Assessment Unit/DA48153
14 September 2015

RE: PROPOSED GOSFORD HOSPITAL REDEVELOPMENT (SSD 6913)

ATTACHMENT 1 - COUNCIL COMMENTS

Figure 17 - a. and b. a. North access on Hospital Road via Racecourse Road. b. North access on Holden Street into the new Emergency Department drop off, and Mental Health Sallieport (Source: TTW, 2015)

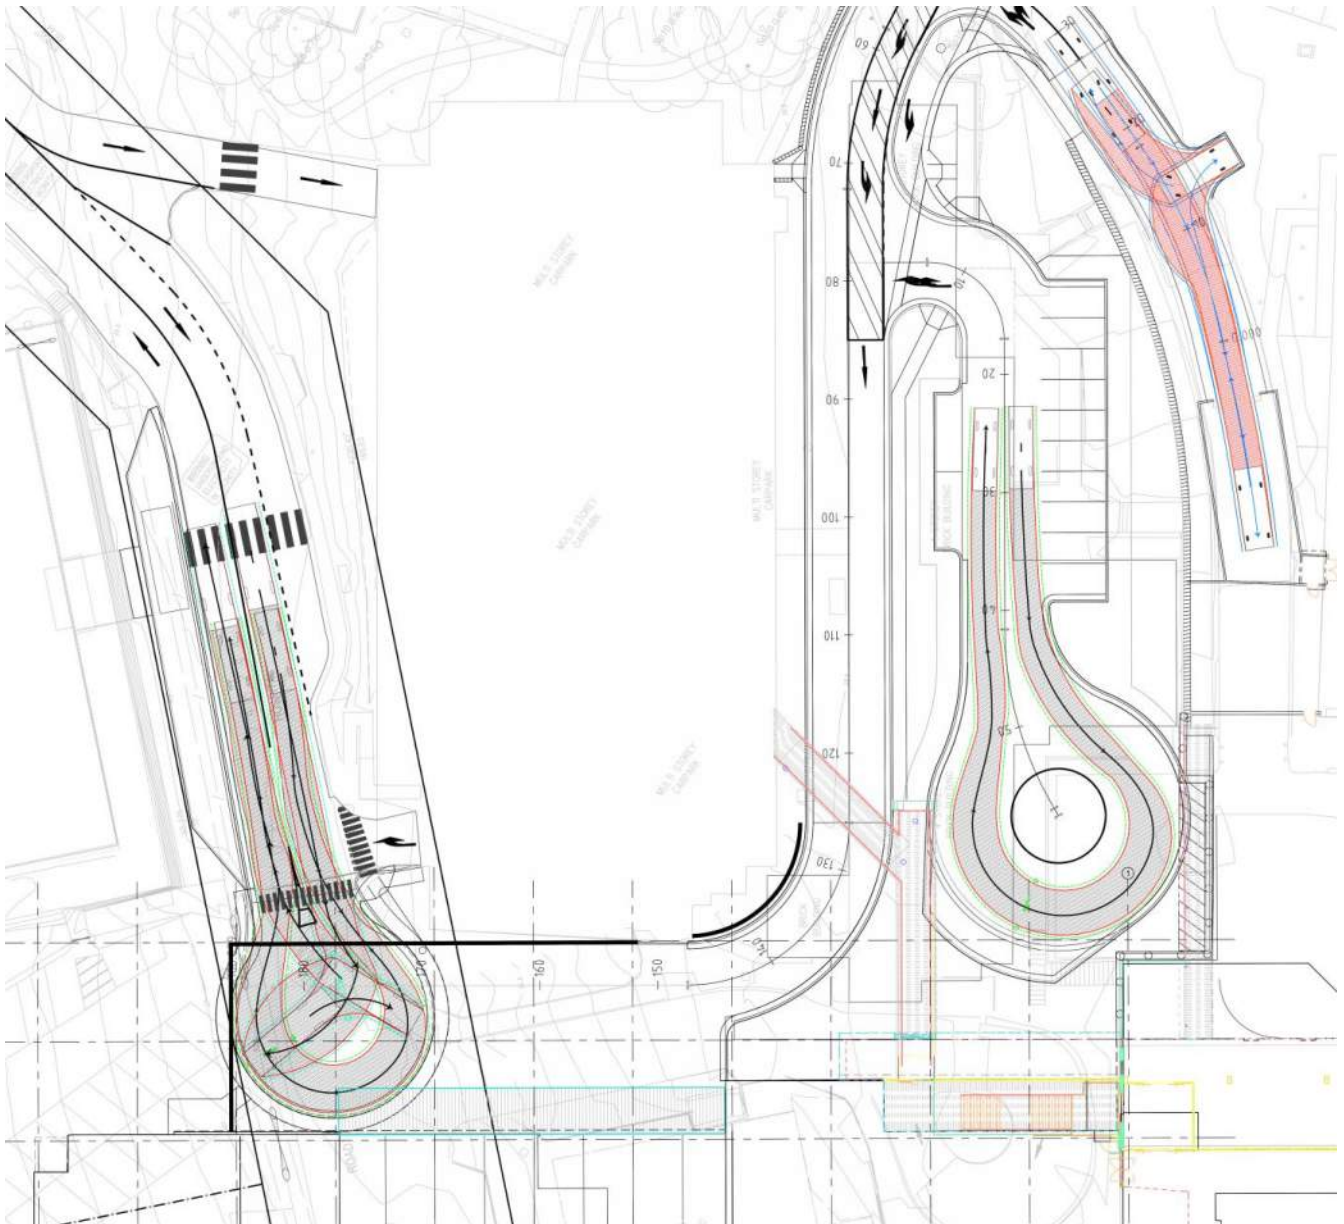
- **Section 7.6.5 Hospital Road / Racecourse Road.** The project proposes to construct a mid-block closure of Hospital Road, converting the northern section to a two-way traffic flow and allowing right turn movements in and out at Racecourse Road. The proposal is to formalise this arrangement by linemarking the intersection to a CHR arrangement (a dedicated right turn lane in Racecourse Road). However, no consideration has been given to the impact of the performance of this intersection due to proximity of the vehicular access to /from Gosford Golf Club and Gosford High School as well as the queuing that occurs along Racecourse Road.

If the proposed design impacts right turns into and out of the Gosford High School and Golf course entrance/exit then this local traffic will be redistributed along Racecourse Rd to travel around the block accordingly (i.e. if right turn in/out are banned then this local traffic would be redirected to other roads such as Bean Street West (for U-turns) and/or Showground Rd and its intersections with Etna Street Bridge and Donnison St Bridge). This issue requires further analysis and confirmation of any impacts and identification of, and commitment to address, identified impacts.

- a. Intersection of Racecourse Road and Hospital Road generally in accordance with the concept indicated in Figure 13 – *Racecourse Road / Hospital road Intersection Improvements* of the SSD Civil engineering Report prepared by Taylor Thompson Whitting (NSW) Pty Ltd Reference 141191 dated 25 June 2015 (Appendix 13 of the Environmental Impact Statement). These works shall include full width road pavement, including kerb and guttering, subsoil drainage, footpath formation, drainage on both sides of the road in Racecourse Road. Suitable access to the Gosford Golf Club is to be provided in the design. Pedestrian refuges are to be provided in the traffic island on the eastern side of the intersection in Racecourse Road, and within the entry area of Hospital Road to facilitate pedestrian movements around the intersection. The final design is to be prepared in consultation with Gosford City Council and Roads and Maritime Services.

Figure 22 - Potential Bus Routes and Bus Stops

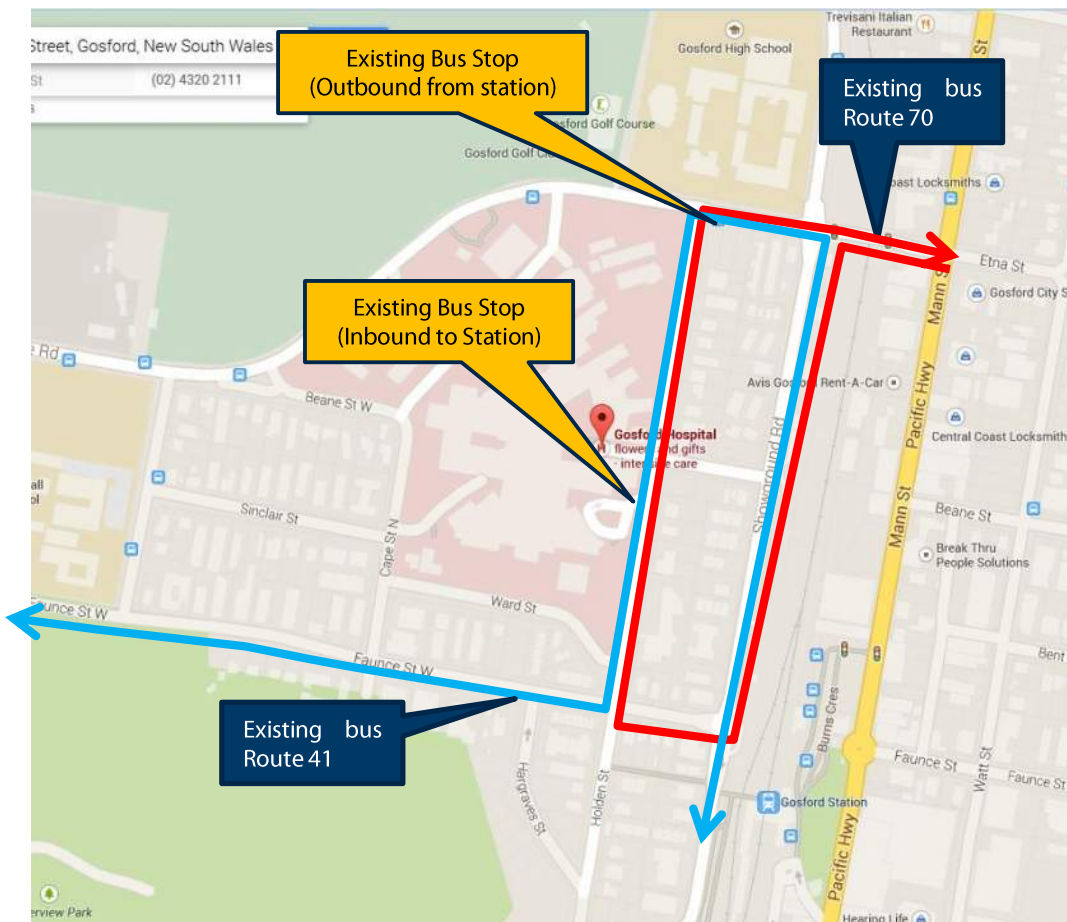
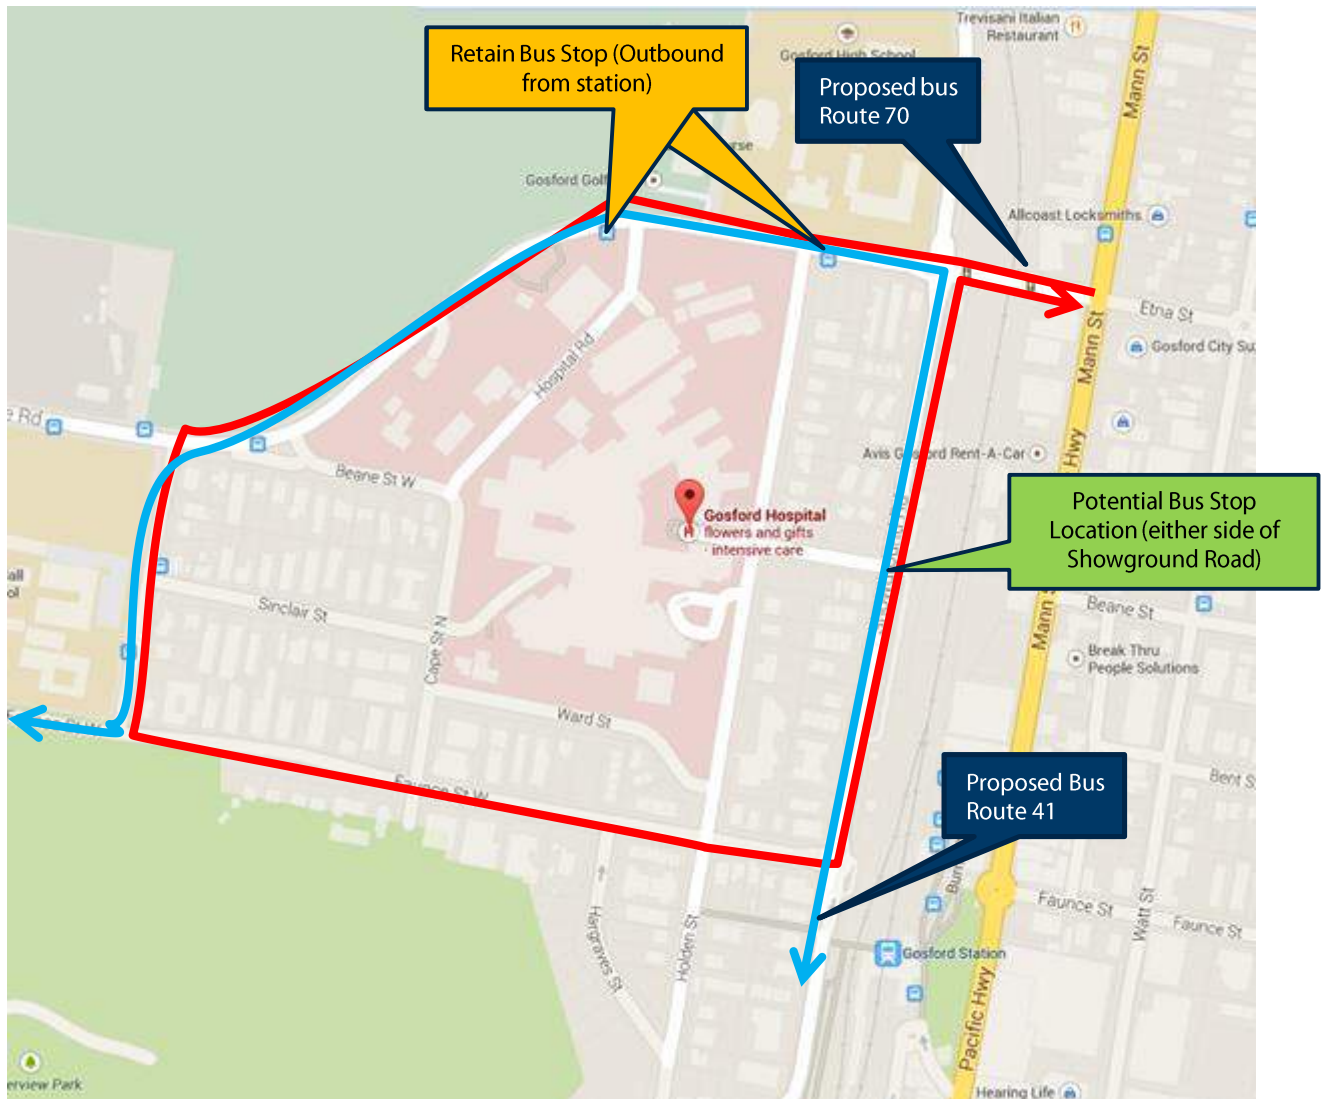
- **Etna St Railway Bridge** - Widening should be at least **5 lanes** to accommodate right turning traffic into Showground Rd or Mann Street. Current footpath widths are also substandard and require widening.
- **Showground Rd/Racecourse Rd** - Option 1 above is not supported as it has no pedestrian facilities.
- **Hospital Road/Racecourse Rd** - Upgrading proposed linemarking treatment for right turn movements could impact left and right turn traffic movements into the existing access road for Gosford High School and adjoining golf course. More detail is requested to clarify impacts.

Figure 23 - Physical Measures to Improve Sustainable Transport

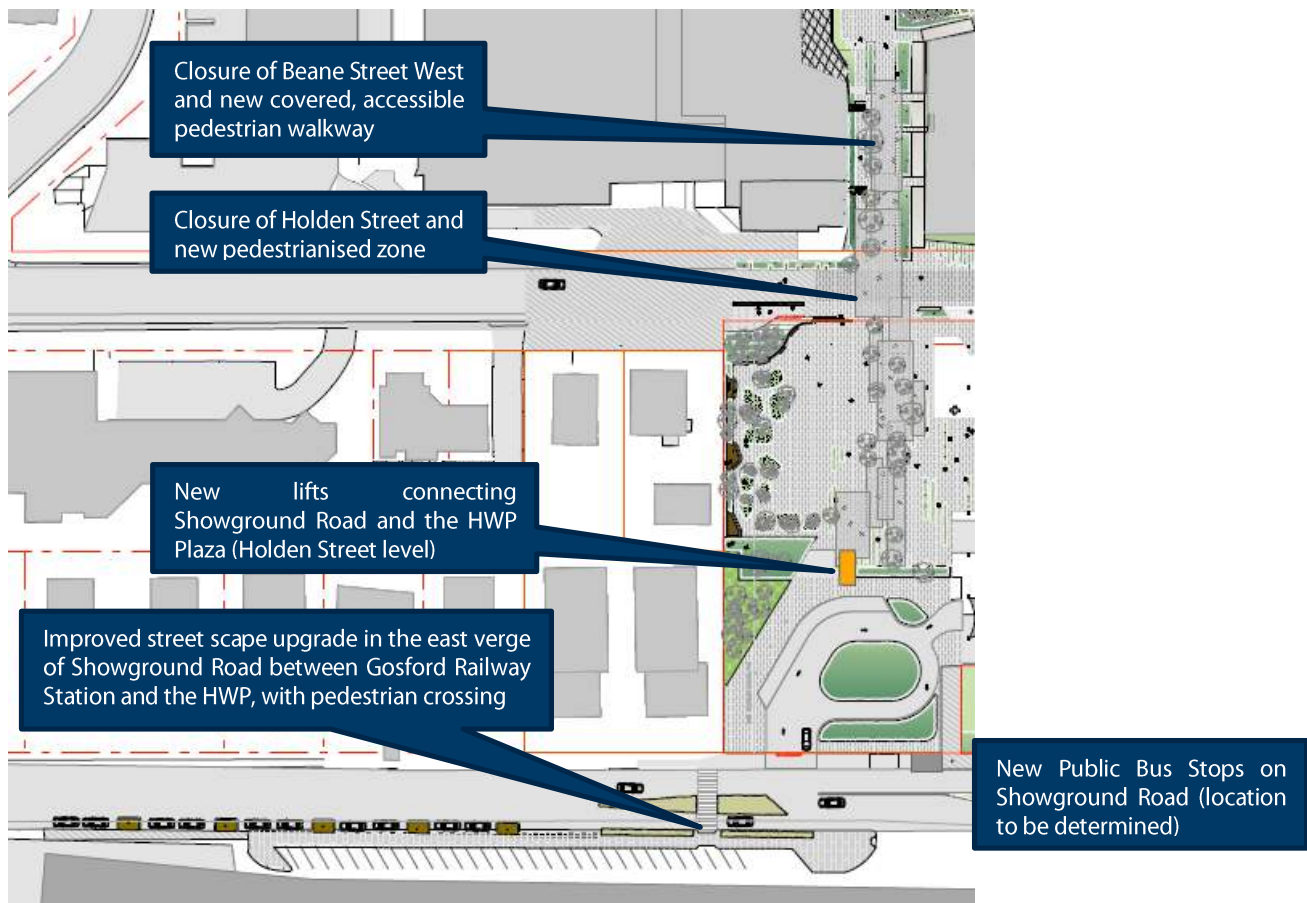
- **Section 7.11 State Plan Targets and Measures to Increase Sustainable Transport.** Goal 10 discusses the proposal to provide a pedestrianised area on Holden Street to improve pedestrian connection between the Hospital and the proposed carpark, Showground Road and Railway Station. The proposal provides for pedestrian access from Showground Road through the ground floor level of the multi-storey carpark to elevators to the Holden Street level. However, pedestrians still would have to negotiate the steep grade from Holden Street to the Hospital entrance which will be unsuitable for elderly / disabled pedestrians.

Accordingly it is considered that visitors are likely to try and park at the higher levels around Holden Street to avoid the walk up the hill from Holden St to the main hospital entry.
